The Planning Inspectorate

Your ref: EN010125

Date: 25 April 2025

Dogger Bank South Offshore Wind Farms Project: Environment Agency response to Issue Specific Hearing 4 Action Points and Rule 17 letter

Figure: 20-6b	Drawing No: PC2340-RHD-ON-ZZ-DR-Z-0716	
Co-ordinate system: British National Grid	Page Size: A3	Scale: 1:50,000
Project: Dogger Bank South Offshore Wind Farms	Report: Environmental Statement

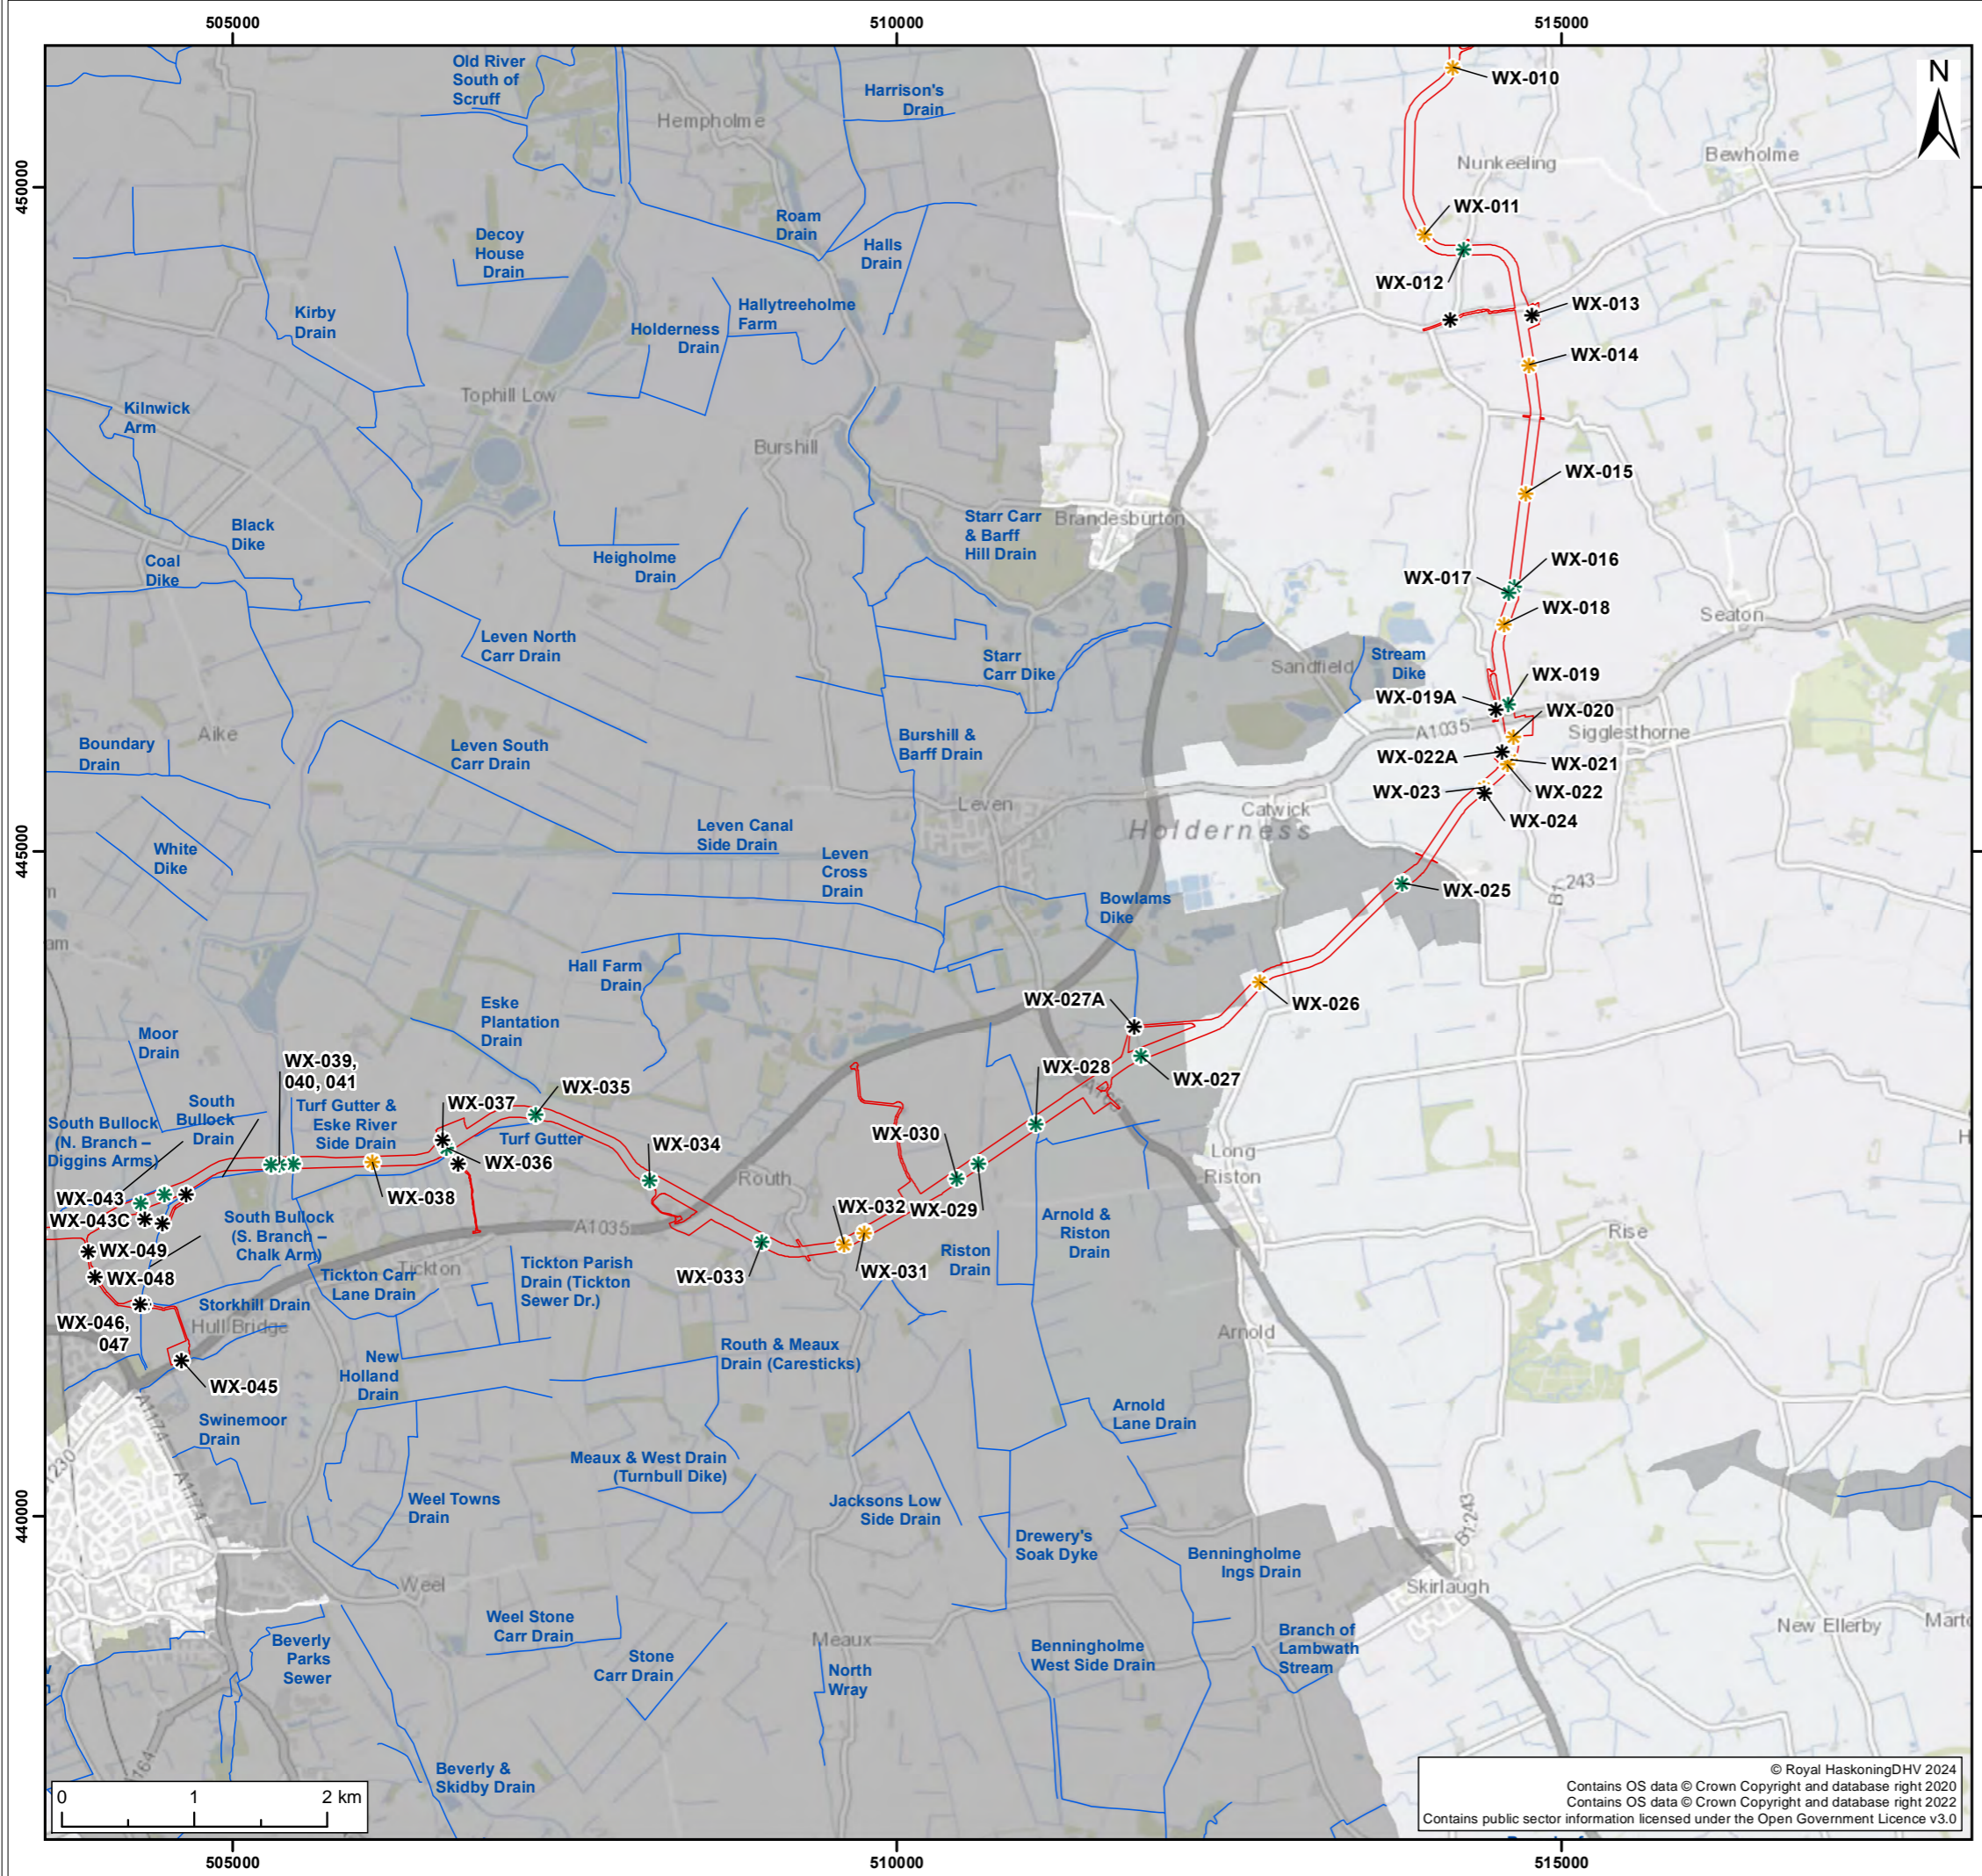
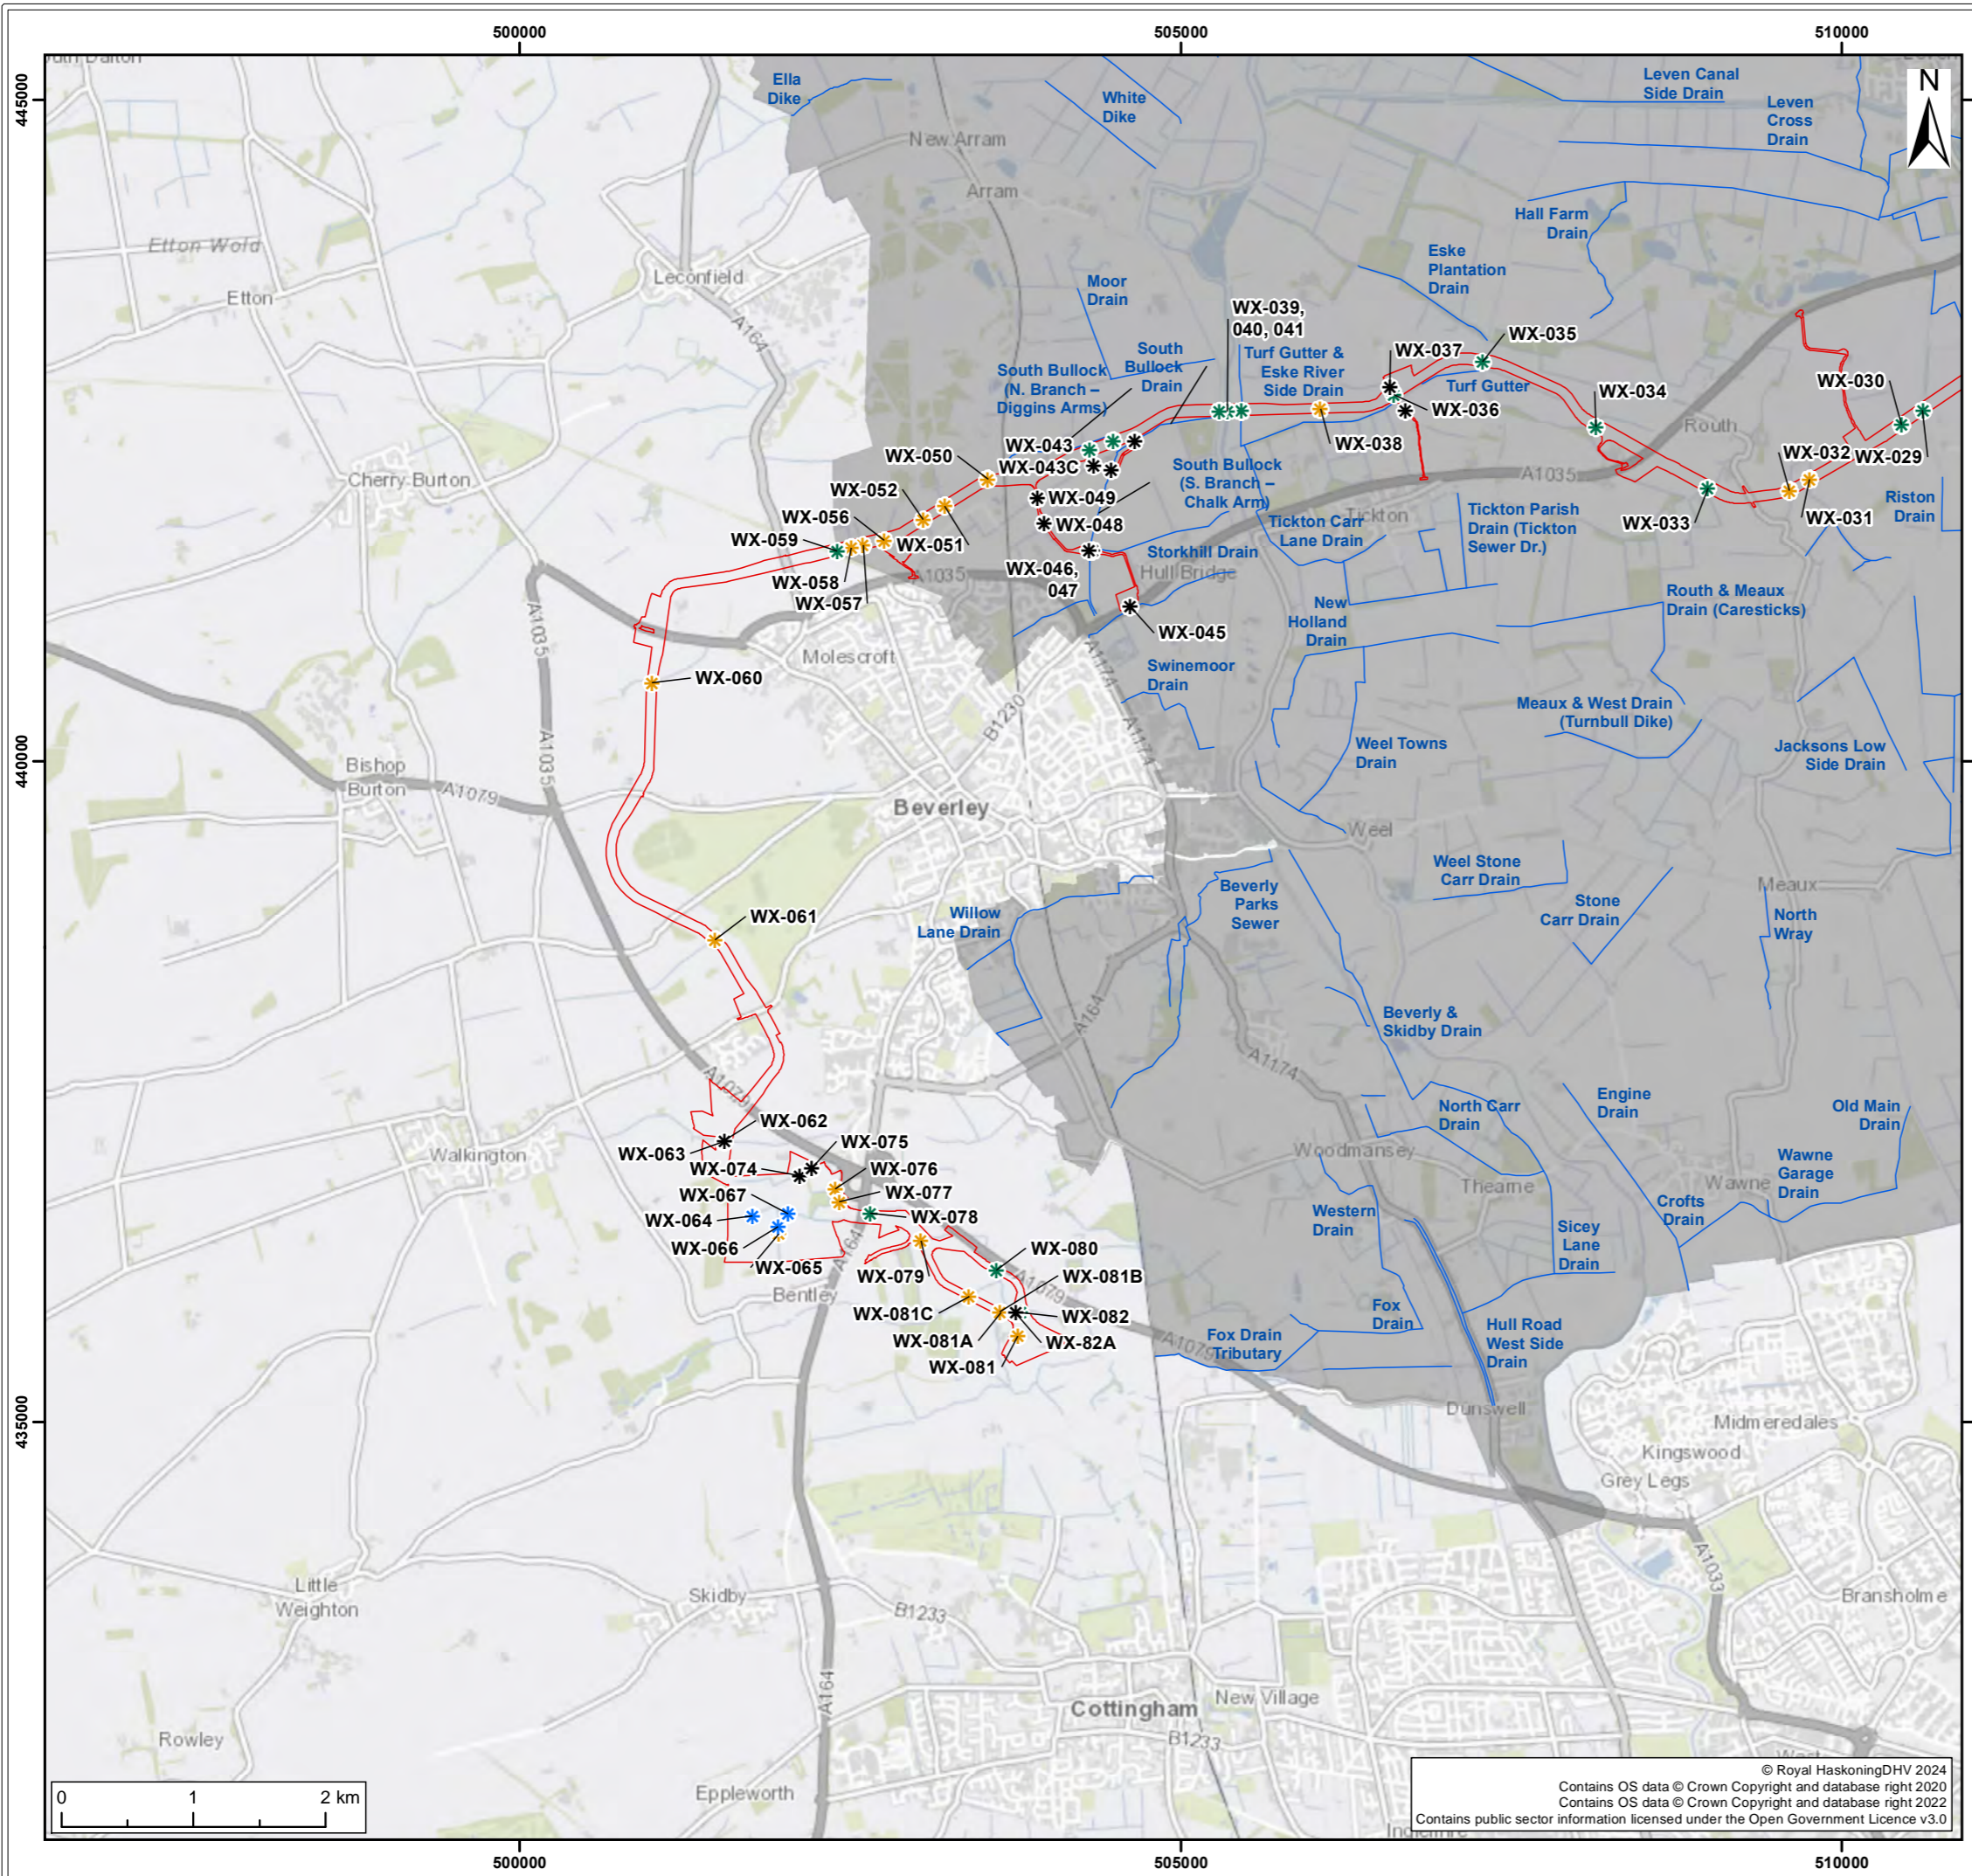
8) To confirm its position on the proposed watercourse crossings Wx-029 and Wx-030 and the associated environmental impacts [REP2-014] - *Deadline 4*

WX-029 will be clear span. The only additional requirement we have here is that the abutments for the crossing are located away from the embankment such that the clear span encompasses the bank on both sides of the watercourse.

WX-030 – this will be culverted. In principle we do not object to the culvert crossing, though the culvert must be appropriately sized to pass a flood flow.

We have let the applicant know that the Meaux and Routh East Drain channel is deep and steep sided so it may be difficult to reinstate the channel when the culvert is removed.

In relation to all watercourse crossings whether clear span or culverted we would expect that the sites are reinstated to the existing conditions once the temporary crossings are removed.

Therefore, we have asked the applicant whether reinstatement and monitoring after the crossings have been removed could be included either in the proposals, or within the requirements of the DCO. We will be meeting with the applicants and our legal team to understand whether this is best secured through the requirements or through the protected provisions.

WX-030 – this will be culverted. In principle we do not object to the culvert crossing, though the culvert must be appropriately sized to pass a flood flow.

We have let the applicant know that the Meaux and Routh East Drain channel is deep and steep sided so it may be difficult to reinstate the channel when the culvert is removed.

We are pleased to see this has been incorporated, however we would also like this to be extended to where temporary crossings are removed, such as the culvert crossing at WX-030.
